From: Zac Denton <Zac.Denton@arun.gov.uk>
Sent: 21 April 2020 11:30
To: Planning.Responses <Planning.Responses@arun.gov.uk>
Subject: FW: AB/11/20/DOC

Consultation response

AB/11/20/DOC

'Unisex' Shared Space Elevation. 1:20

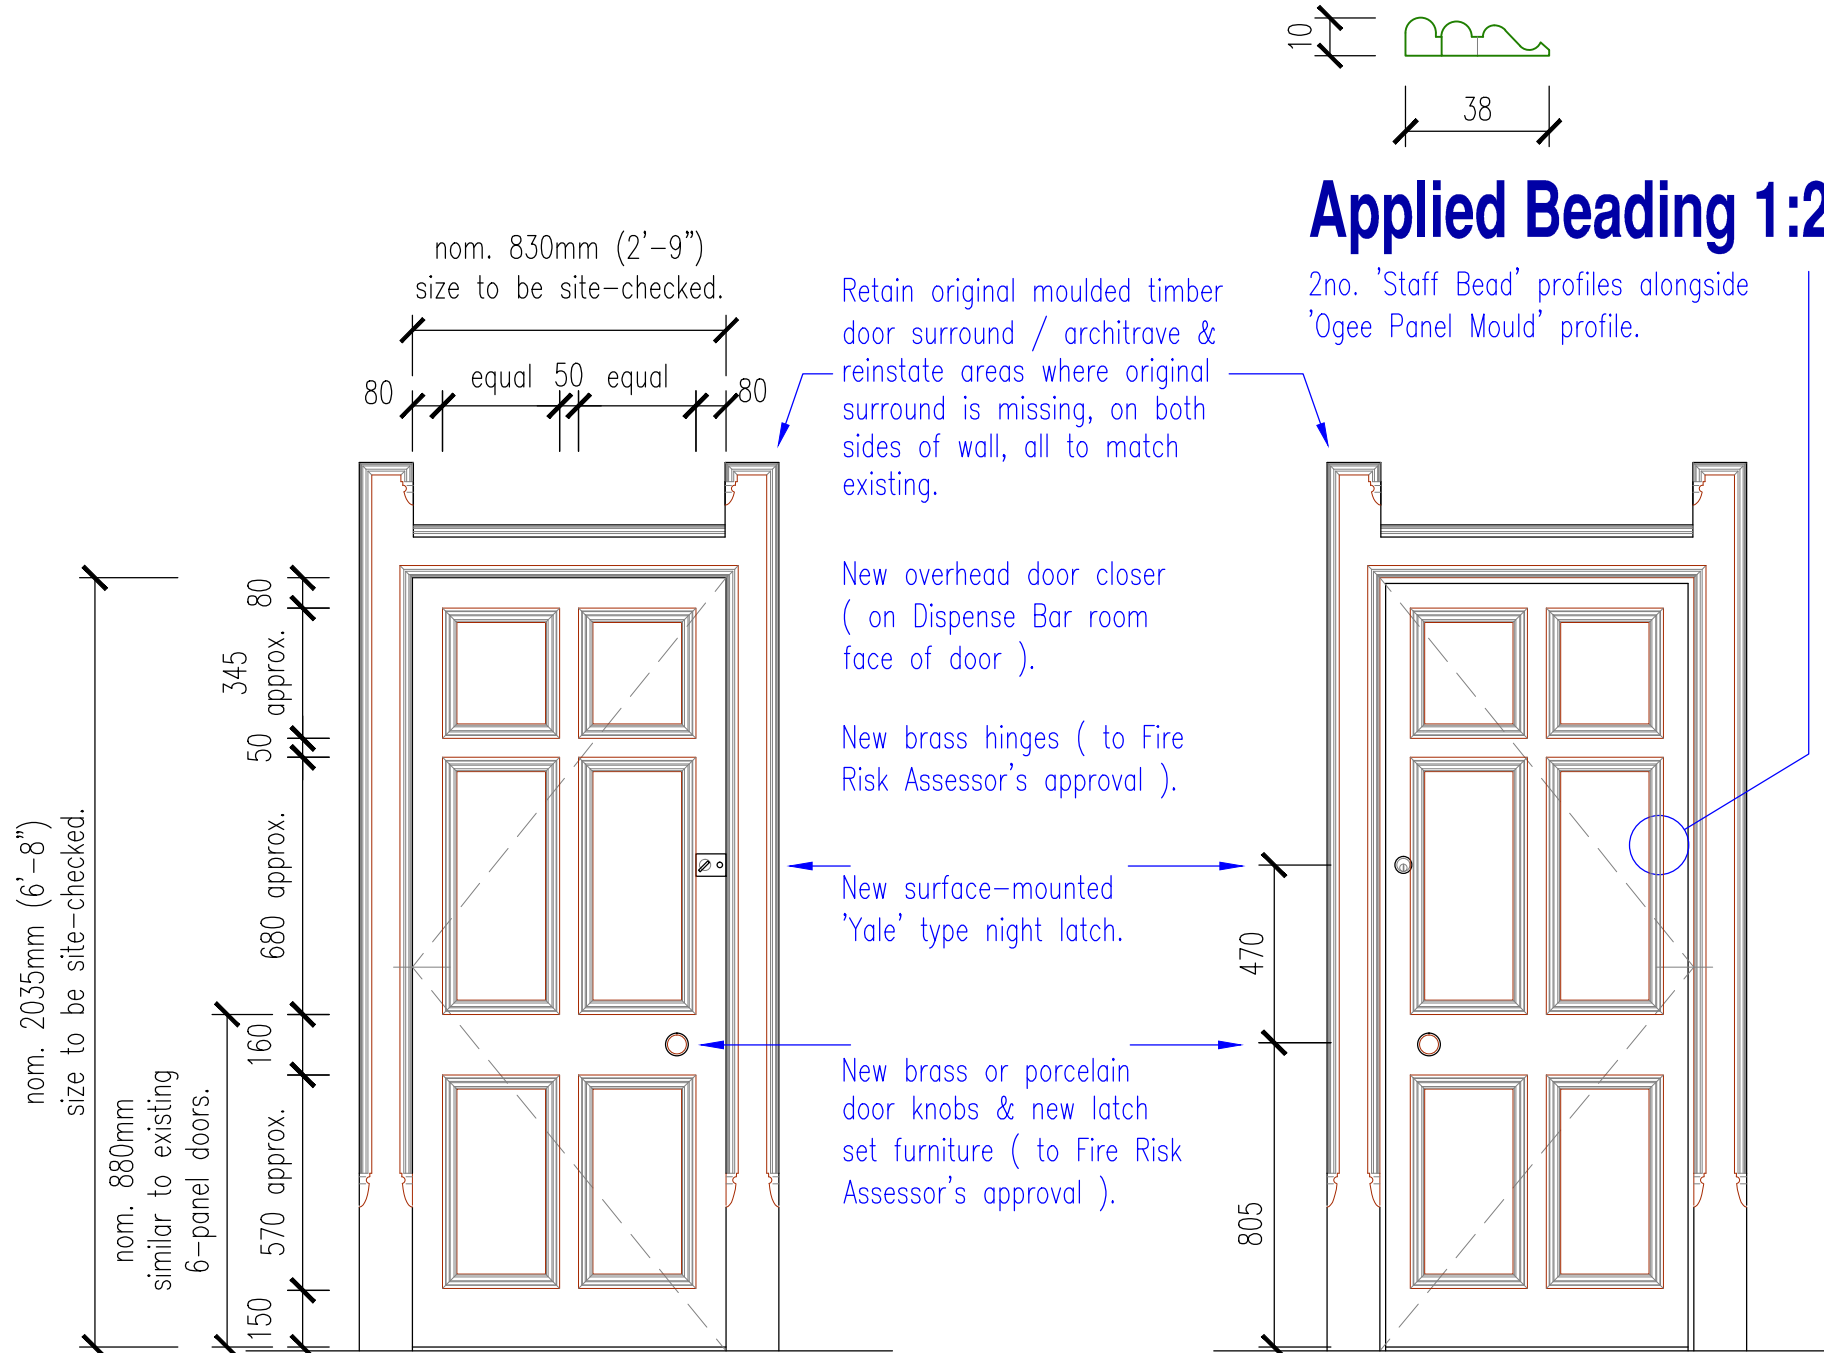
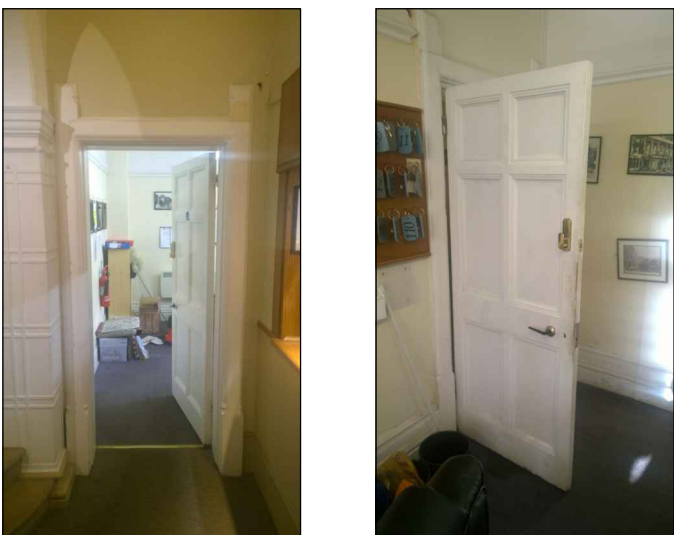
Whilst the elevations of the proposed doors appear to reflect that of others within the building, it is unfortunate that they are flush faced blank doors with applied moulding beads, as opposed to being of traditional construction. The effect is a door of limited aesthetic appearance.

I have to state that I do not have the knowledge of how to deal with fire prevention etc. and these comments are made on that basis. It would be preferred if doors of traditional construction/appearance could be used along with Intumescent Products or similar. However, if the proposed doors provide the required safety benefits, they could be supported.
